2024/0797

36 Underwood Avenue, Worsbrough Dale, Barnsley, S70 4AZ

Erection of a single storey side extension.

PROPOSED FRONT ELEVATION
SCALE 1:100 AT A3

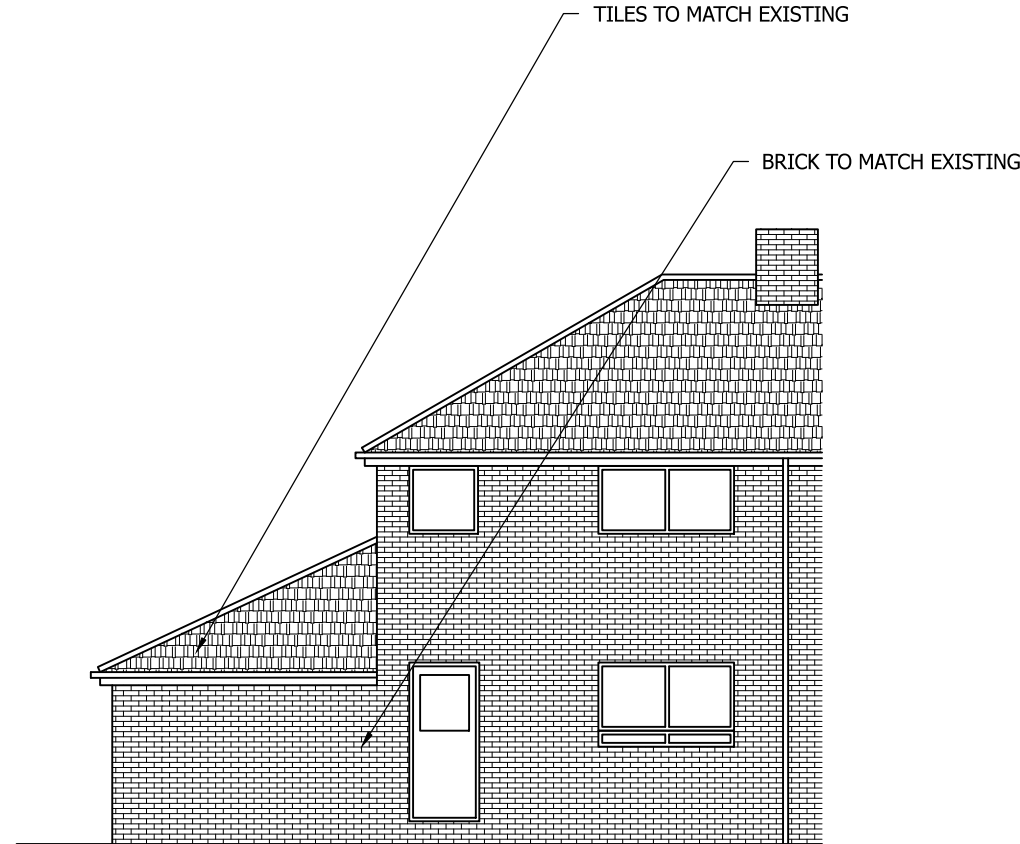
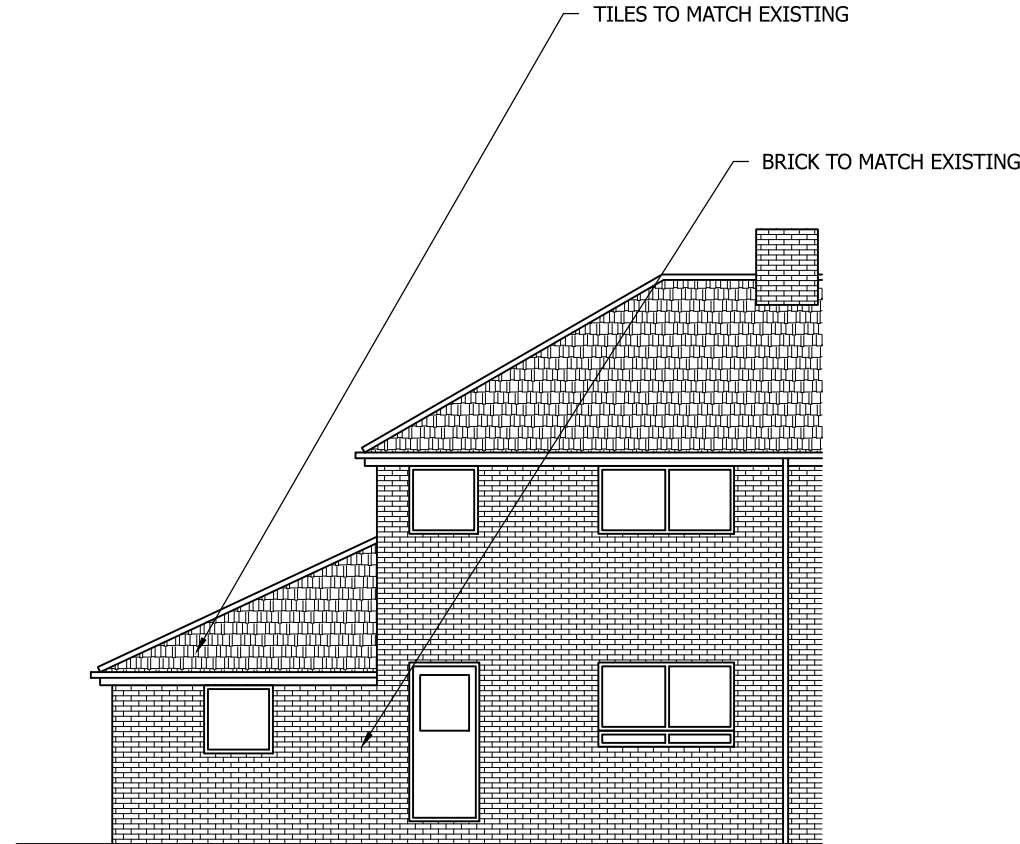
The proposed extension benefits from a hipped roof form with a matching pitch. This allows the proposal to match the existing dwelling and provide a consistent design in keeping with the character of the street scene. Amended plans were submitted to include a window to the front elevation of the proposal. This prevents a blank elevation within the street scene which would detract from the visual amenity of the property. A garage door is provided to the rear elevation which is necessary as access to the site is found towards the northeast corner of the site. Matching brickwork and tiles are

In considering the above assessment, the proposed development is acceptable regarding residential and visual amenity and highway safety. Some concerns we're initially present with regards to the proposed blank front elevation, however these have been addressed in the form of amended plans and elevations and now provides acceptable levels of visual amenity. On balance, this application is therefore recommended for approval.
